YorkshireWater

Your Ref: 2023/92966
Our Ref: Z005219

Land to the rear of 271 Cliffe Lane, Gomersal, Cleckheaton – Demolition of existing dwelling and erection of 97 dwellings including formation of a new access from Cliffe Lane, landscaping, public open space and all associated infrastructure and engineering works (Revised)

Client Quarters Gomersall			
Project Cliffe Lane Gomersall			
Drawing title Drainage Strategy - On Site			
Drawn RT	Chkd	Date FEB 24	Scale 1/500
Contract No. 23054-C-DR	Drg No. 0100	Revision P4

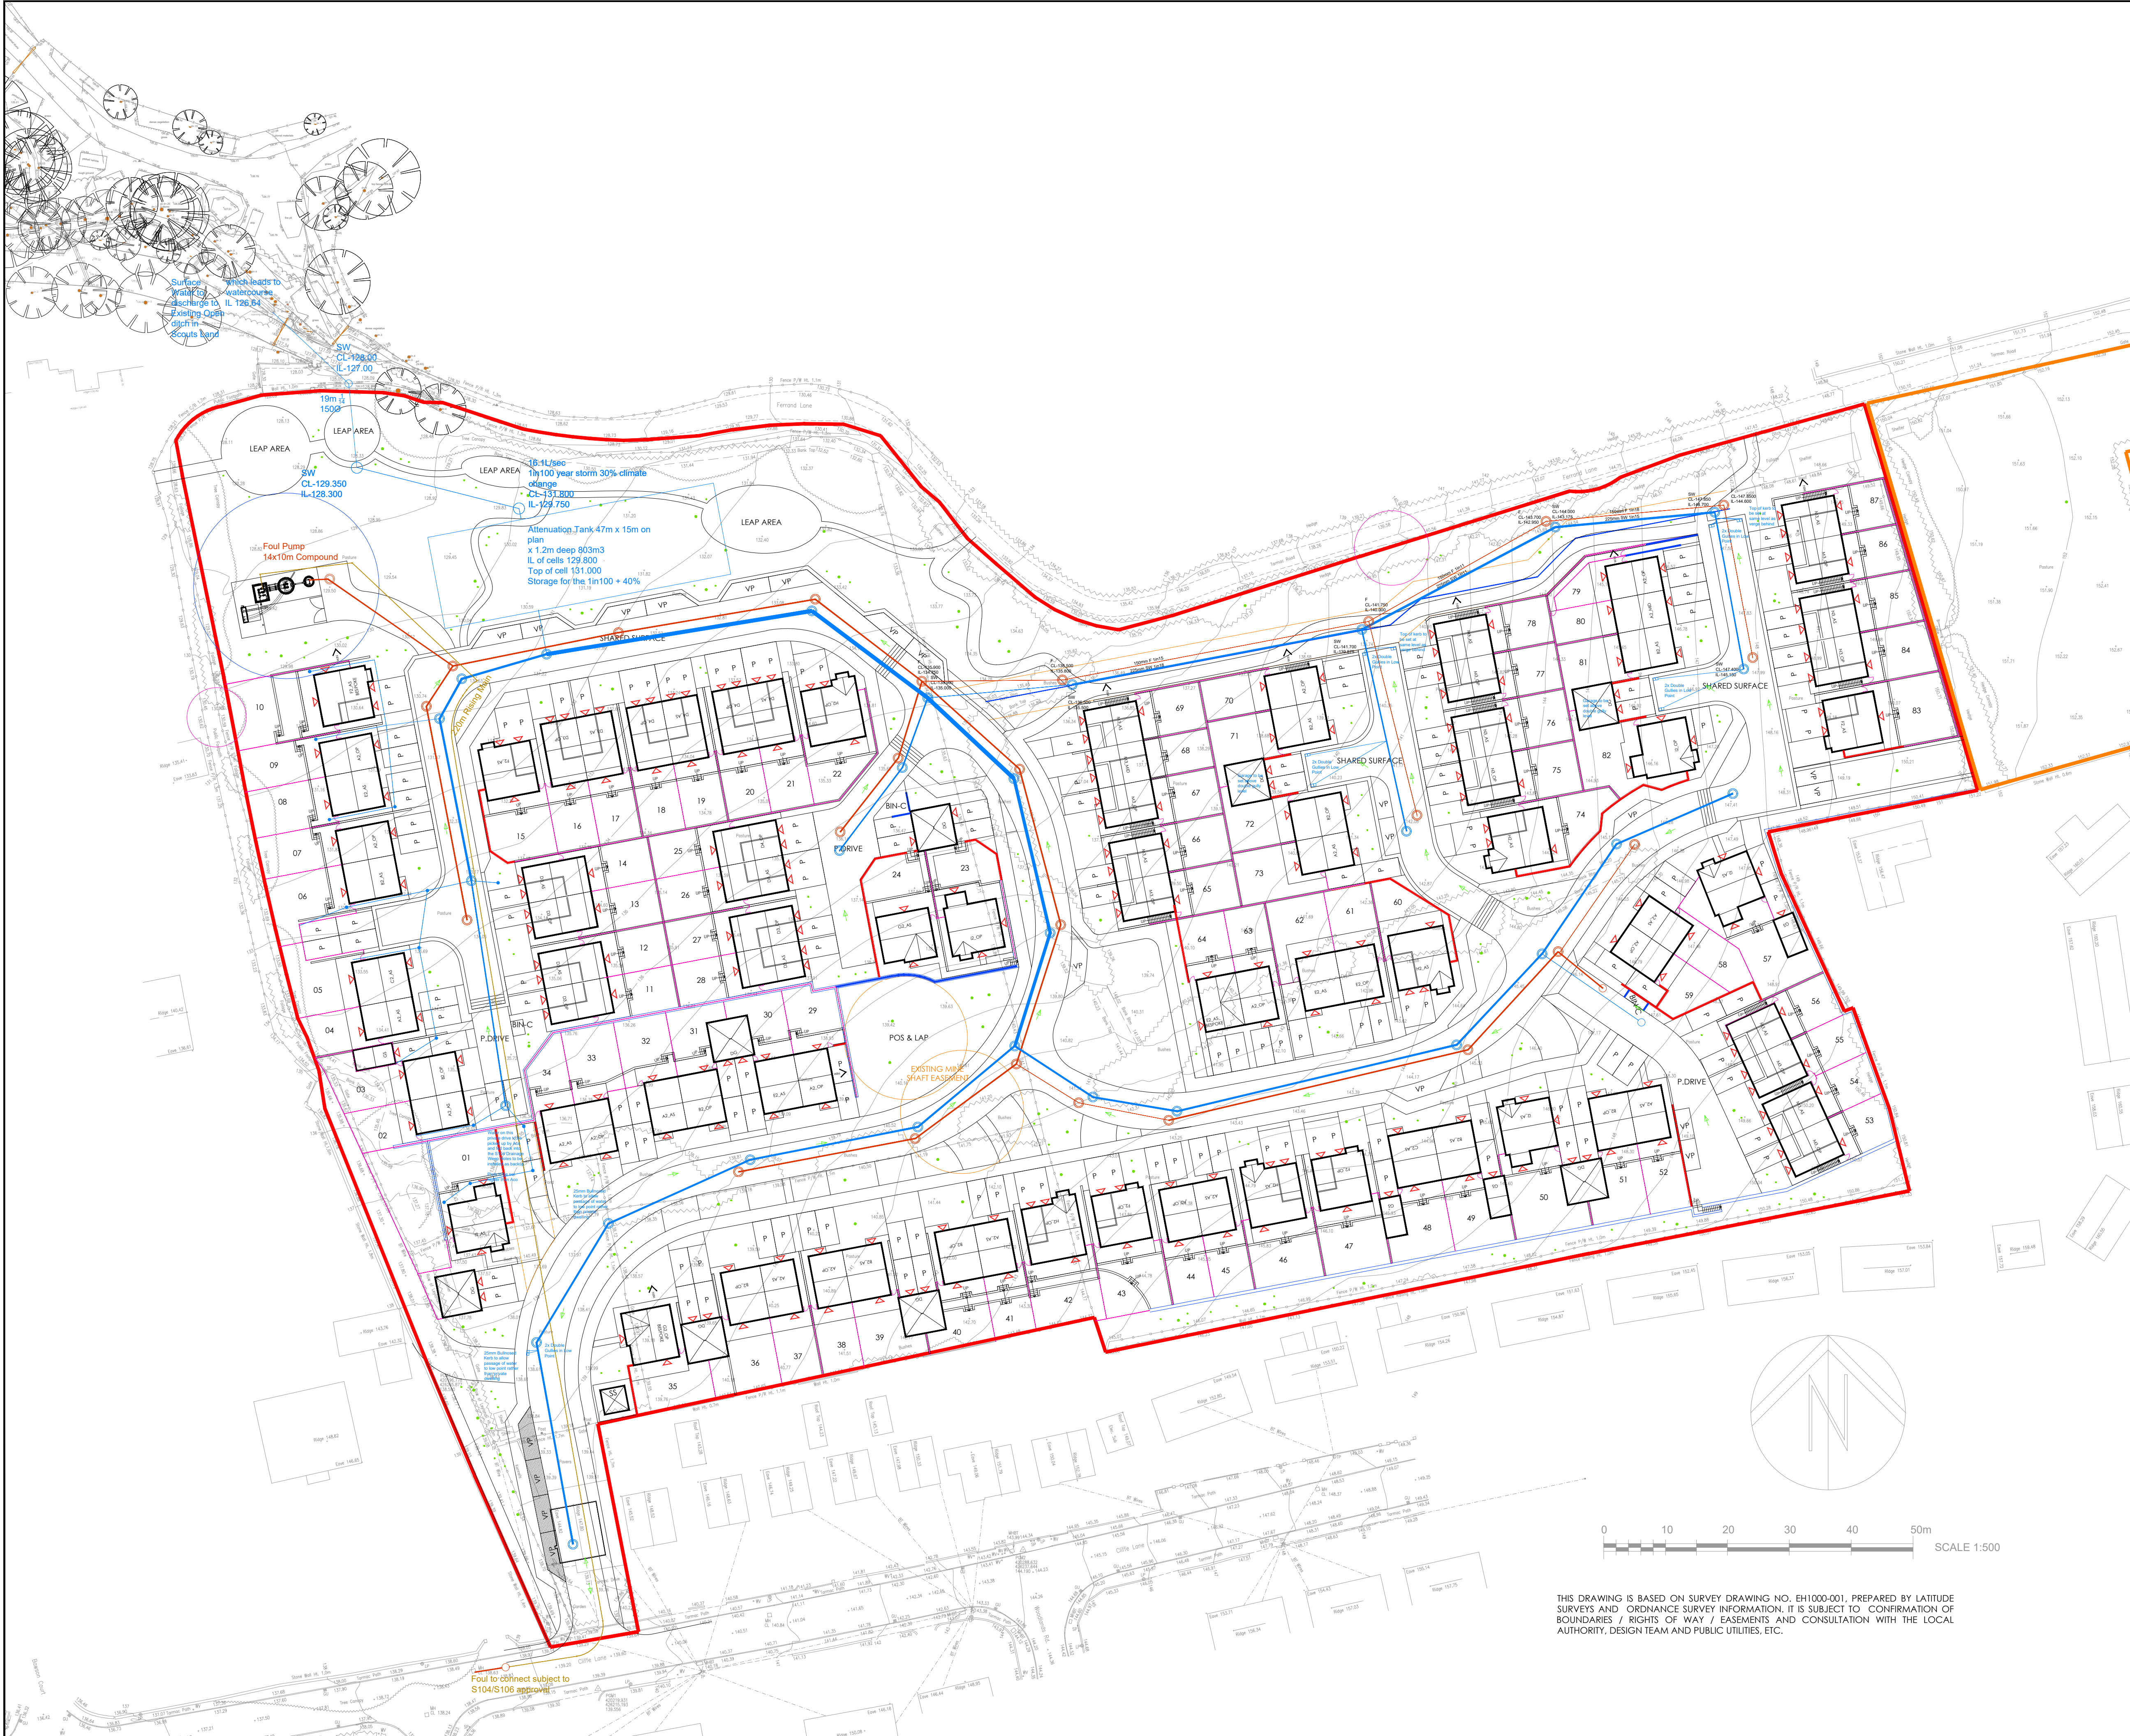
1.) The drainage details submitted on drawing 'Drainage Strategy - On Site' 23054-C-DR (revision P6) dated Feb 2024 that has been prepared by Dart require amendments, but if planning permission is granted, the matter can be dealt with via condition. The following point(s) should be addressed:

a.) the submitted drawing appears to show foul water to be pumped to the public foul water network - no pumped rate has been given.
